Recommendation Report for Planning Permission for Works or Extension to a Dwelling

REF NO: R/191/21/HH

LOCATION: Hobbs Farmhouse
36 Sea Lane
Rustington
BN16 2RE

PROPOSAL: Erection of single storey rear extension to create orangery and creation of en suite on first floor following the demolition of existing outhouse. This application may affect the setting of a listed building.

Drawing: Proposed Elevations

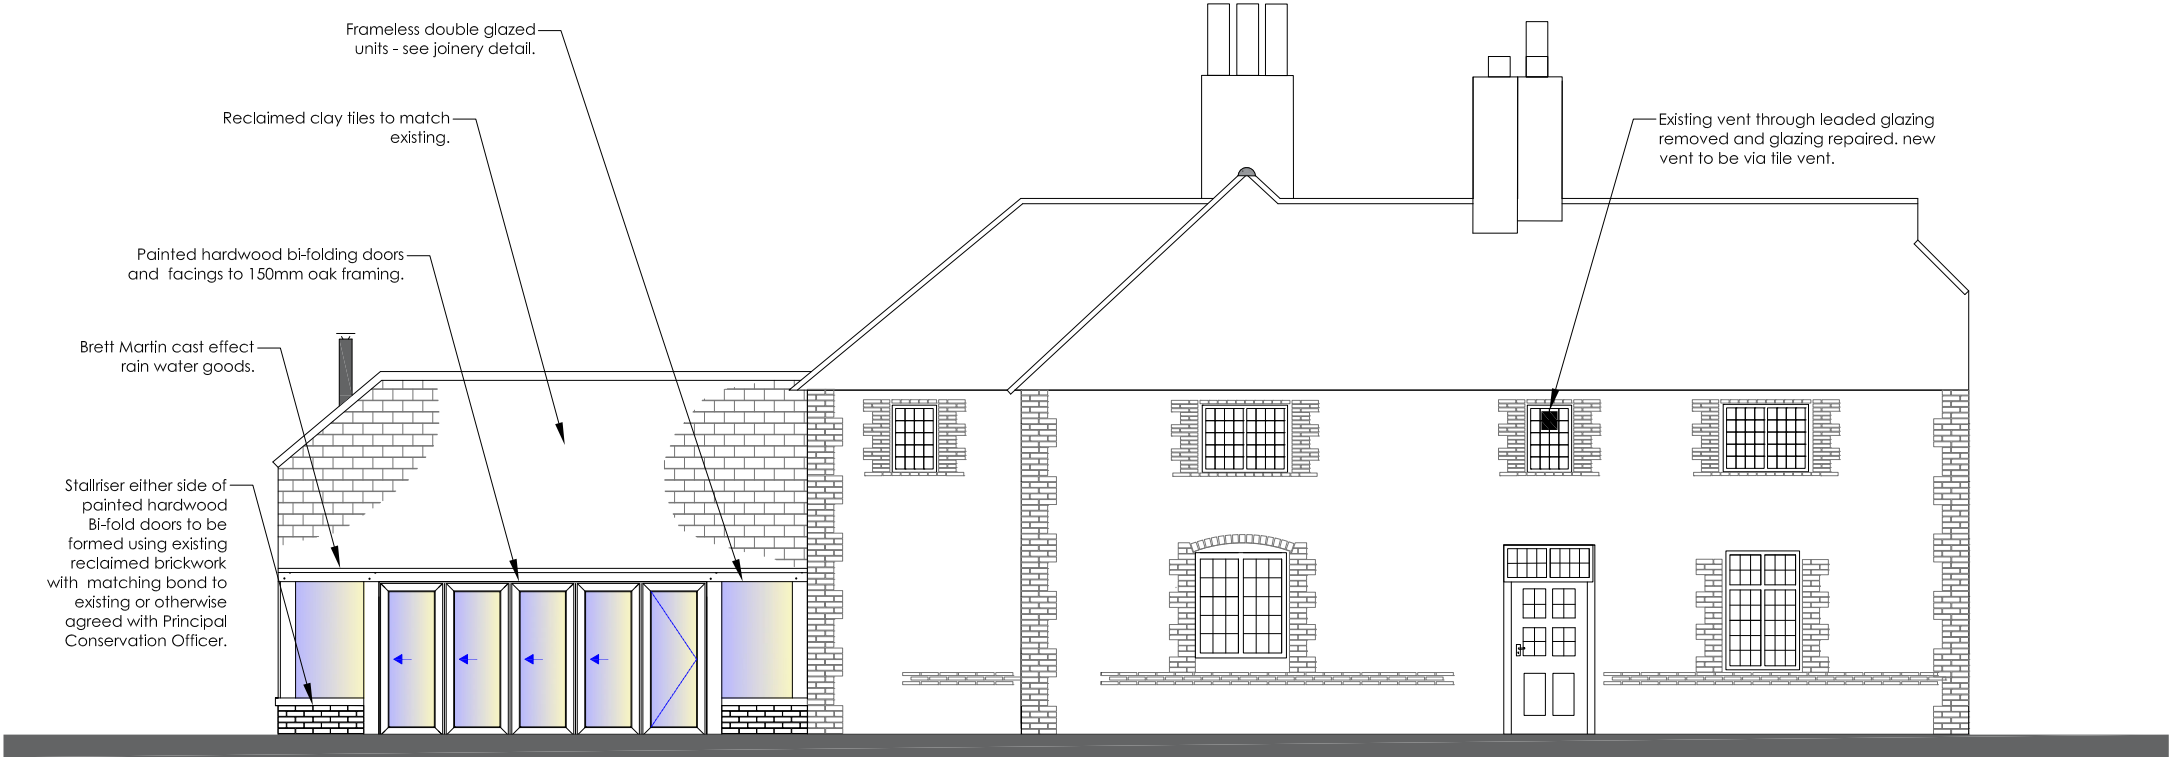
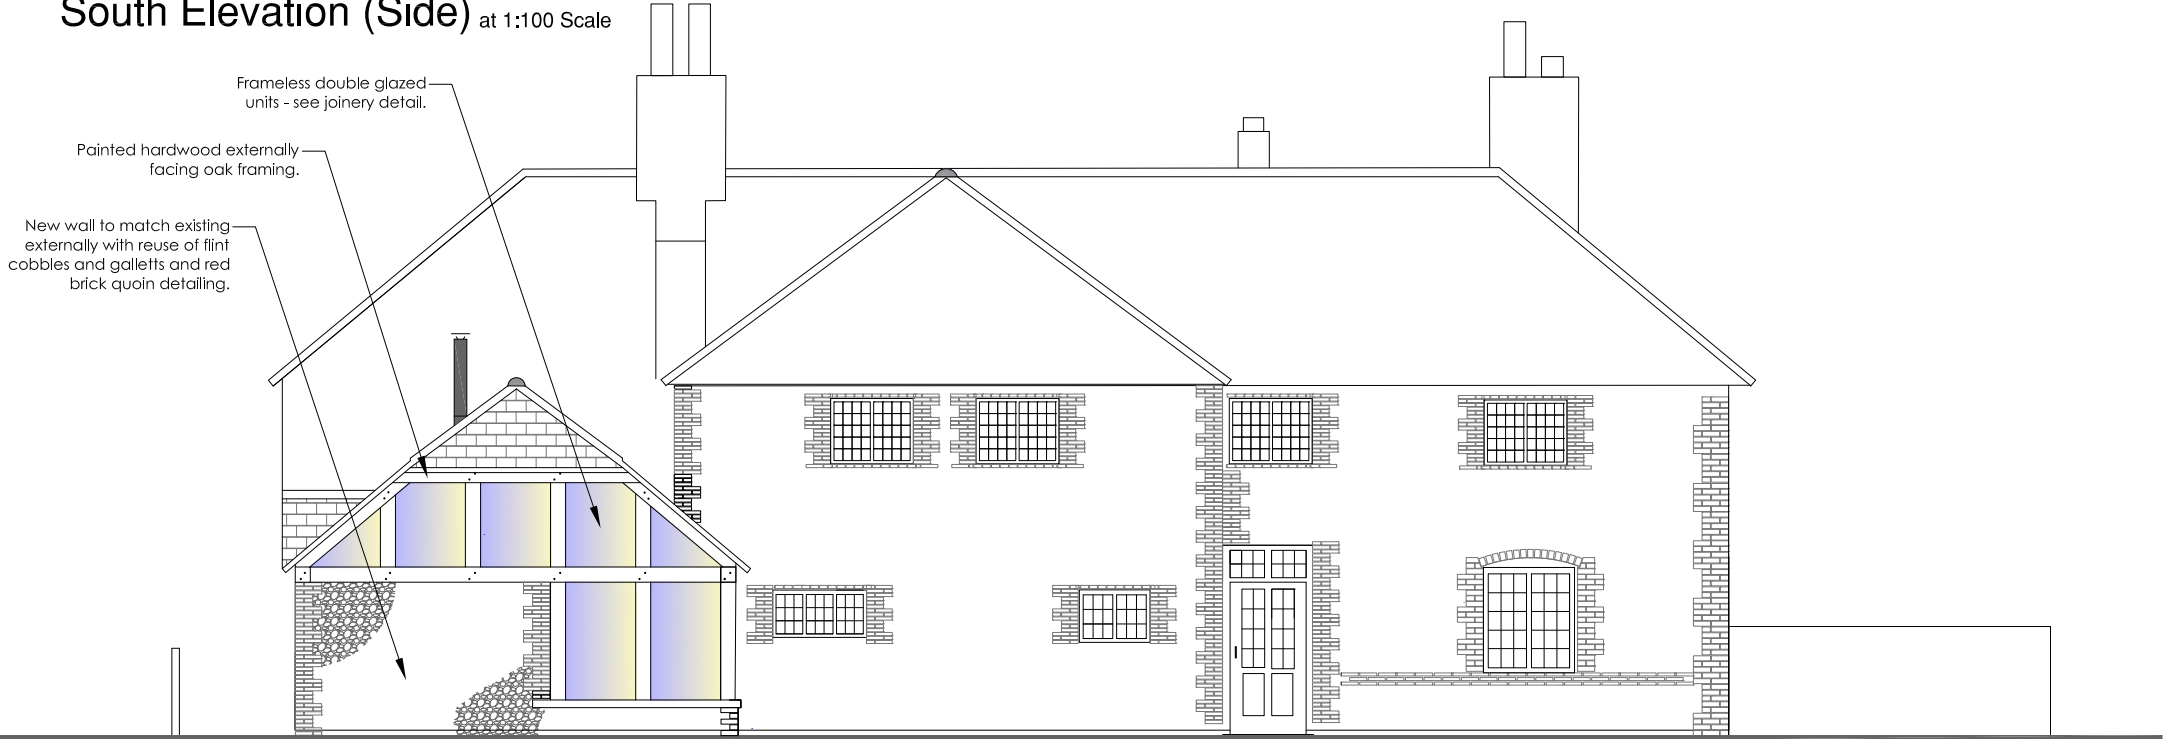
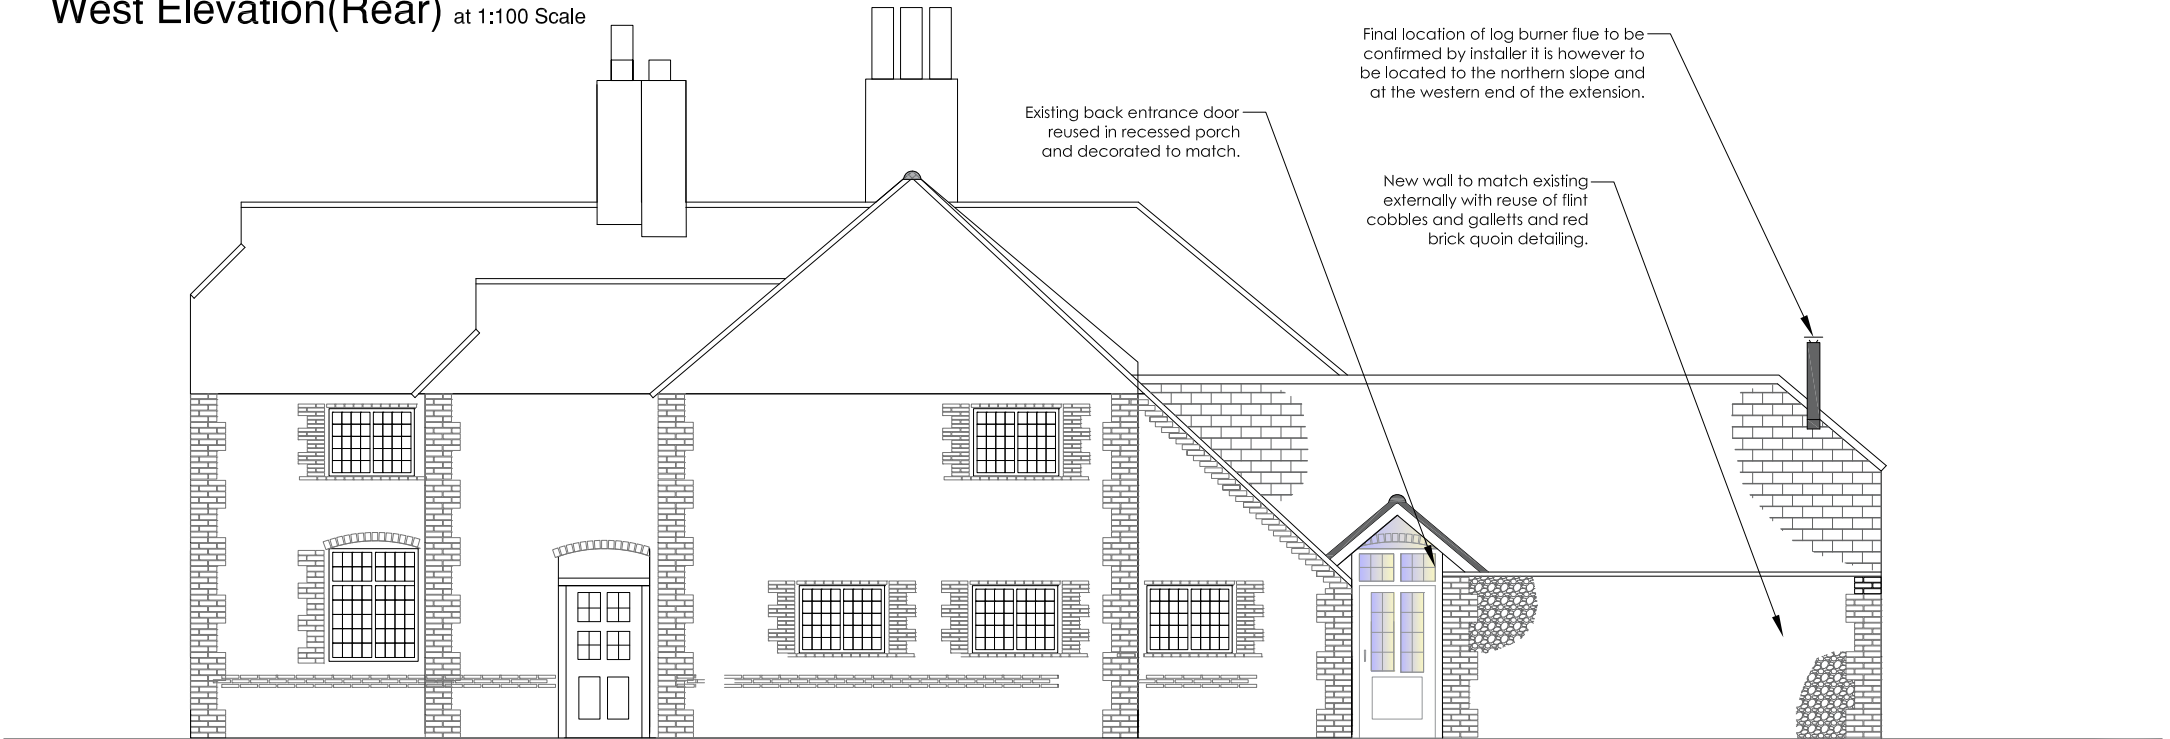
Materials will be reused from the outbuilding which is to be removed, with reclaimed clay roof tiles. The reuse of materials ensures it appears well integrated with the host dwelling and appropriate in design which features brick quoin detailing.

The roof will be relatively high at 4.75m and meets with the eaves of the host dwelling. This has a width of approximately 6m.

The gable end of the roof will feature glazing along with bifold doors and glazing units to the southern and west elevation. Views will be available over the garden of the dwelling and street scene at Farm Way. The proposal is not considered to result in views upon neighbouring properties and will not give rise to adverse overlooking.

Drawing: Proposed Plans

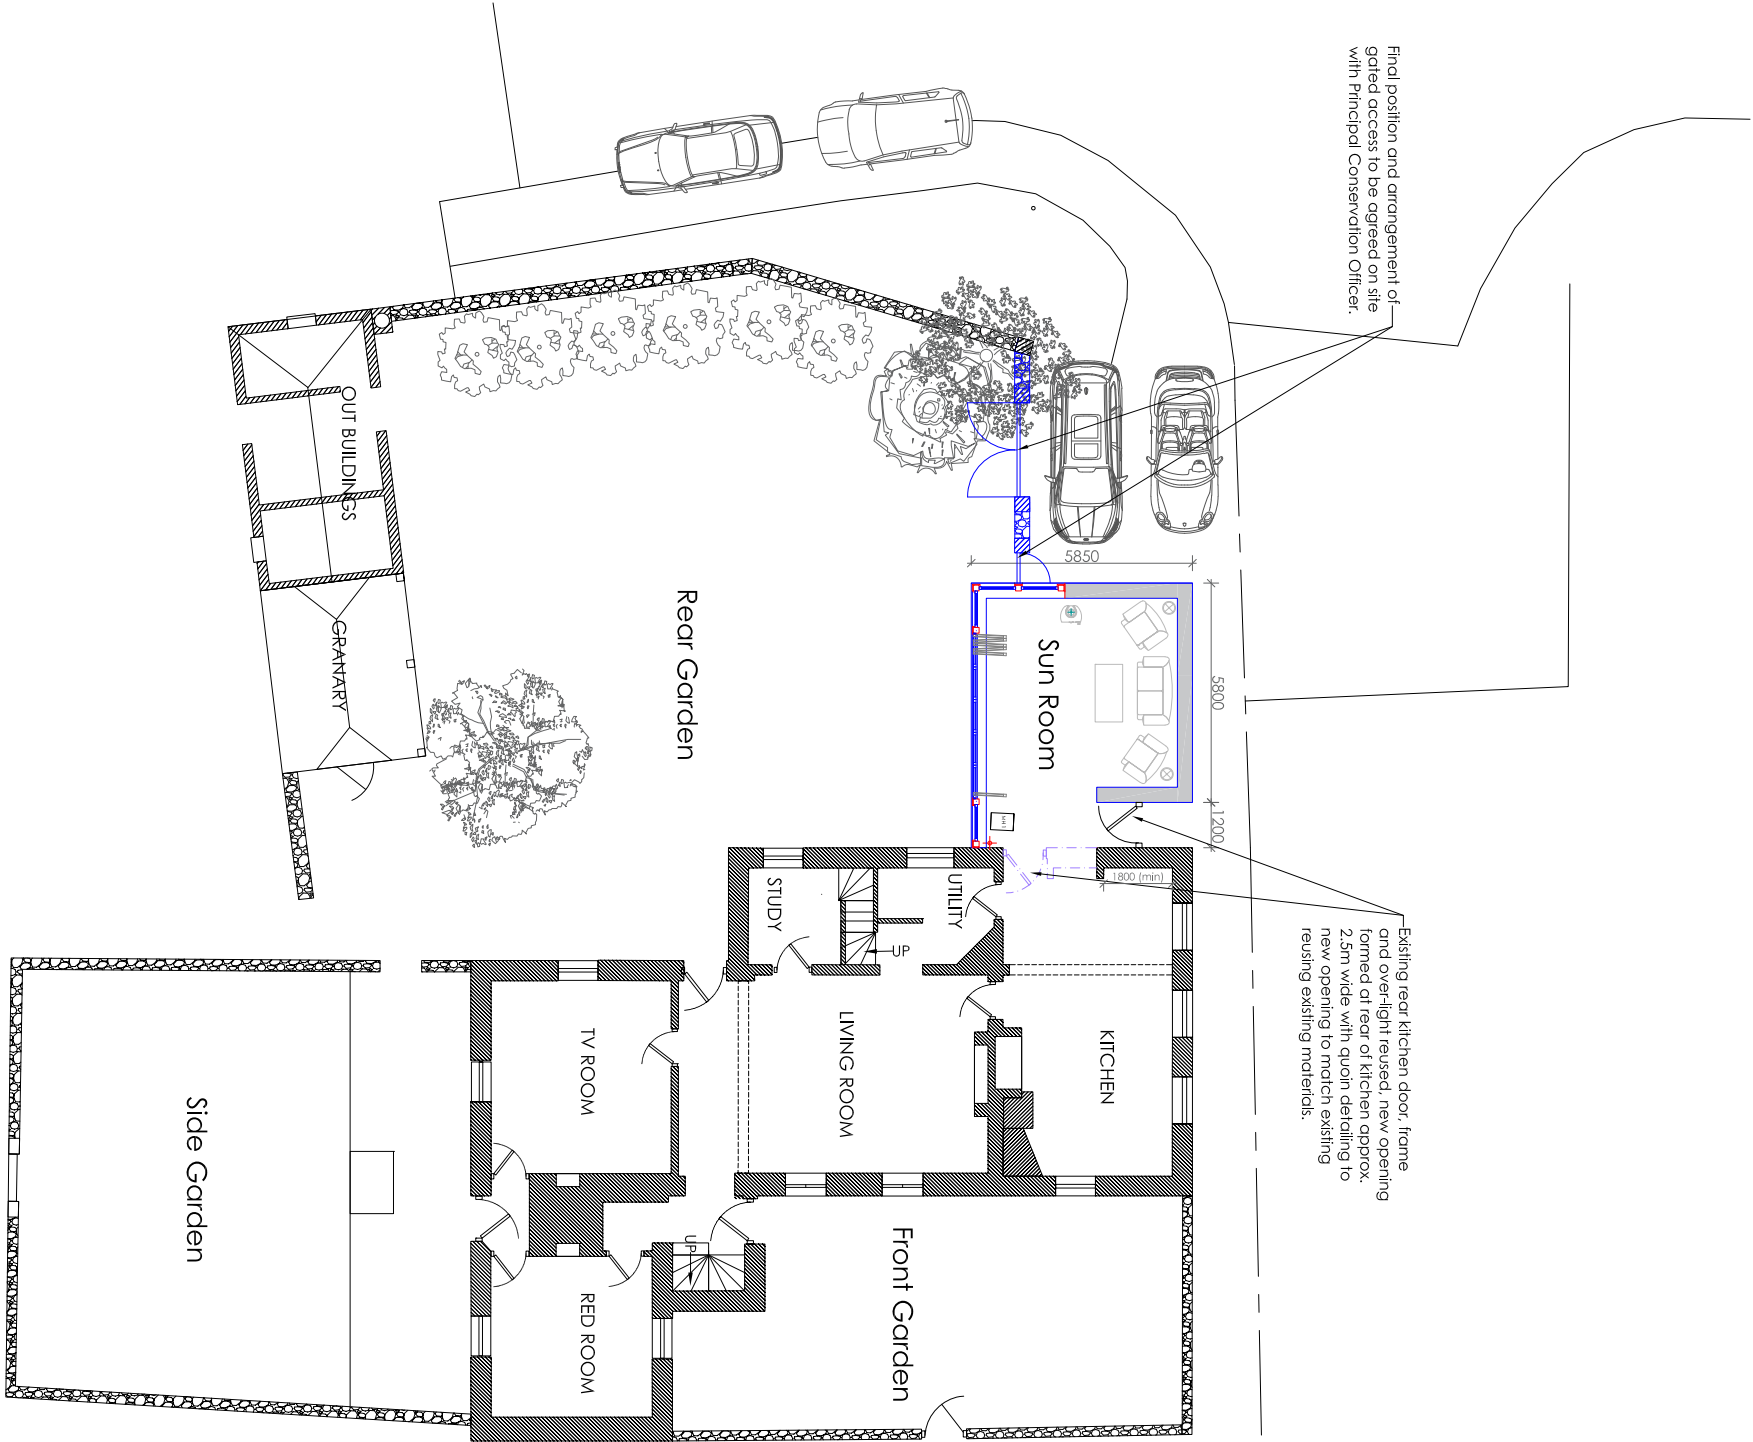
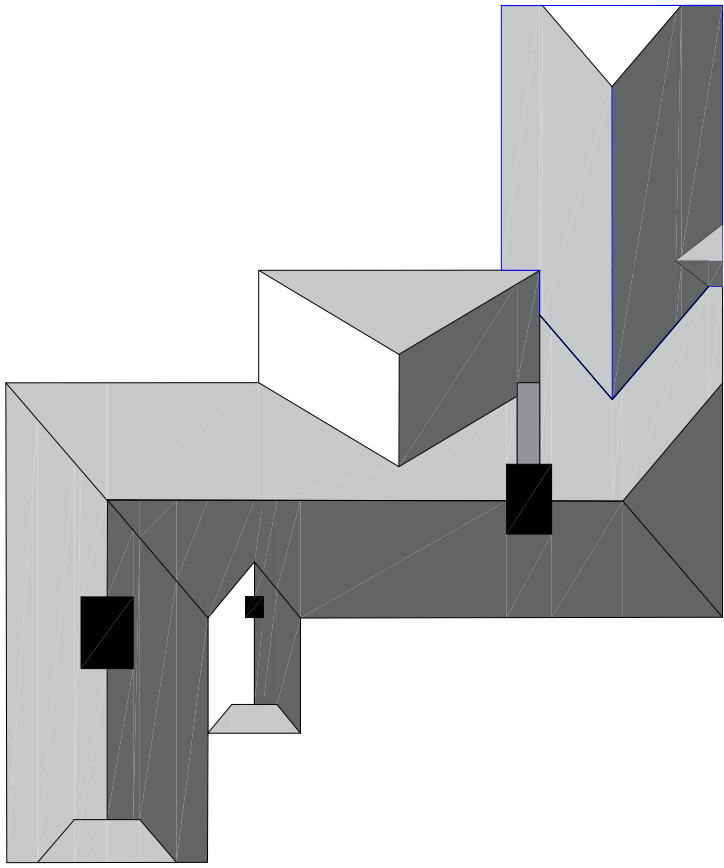
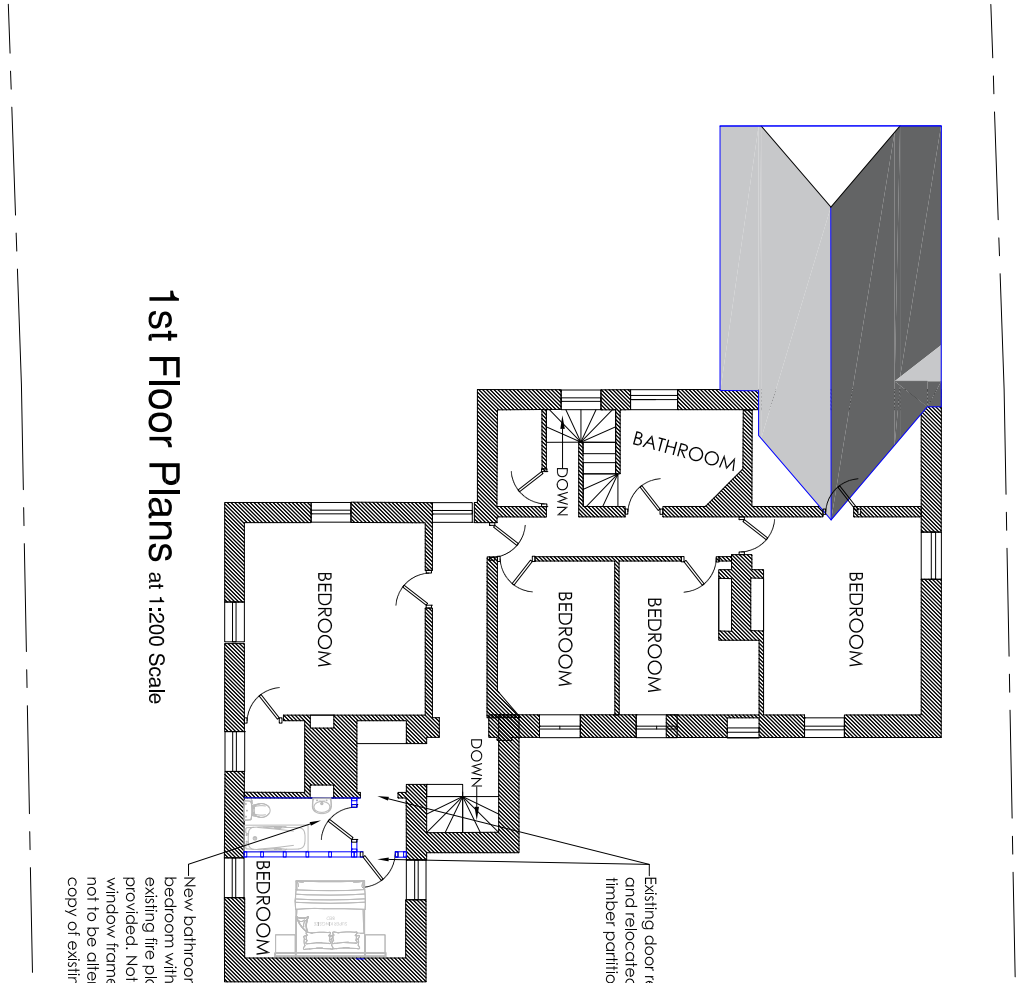
The extension will replace an outbuilding. There is currently a flint wall which joins with the outbuilding. The wall will be partially removed to allow vehicular access and the outbuilding will be removed and replaced with an extension which joins with the host dwelling. The extension has a depth of 7.2m and will add bulk to the property. This does however retain 5.3m to the front of the property and is well integrated and therefore does not appear unduly dominant.

Approximately 1.5m is retained to the northern boundary which features a fence, with an area for parking behind. Around 9m is retained from the side elevation of the extension to the side of the neighbouring dwelling. As such, due to the siting and separation, the extension does not result in adverse overbearing or overshadowing upon amenity.

The creation of the ensuite is acceptable and fully reversible, appearing not to require external plumbing which is a positive.
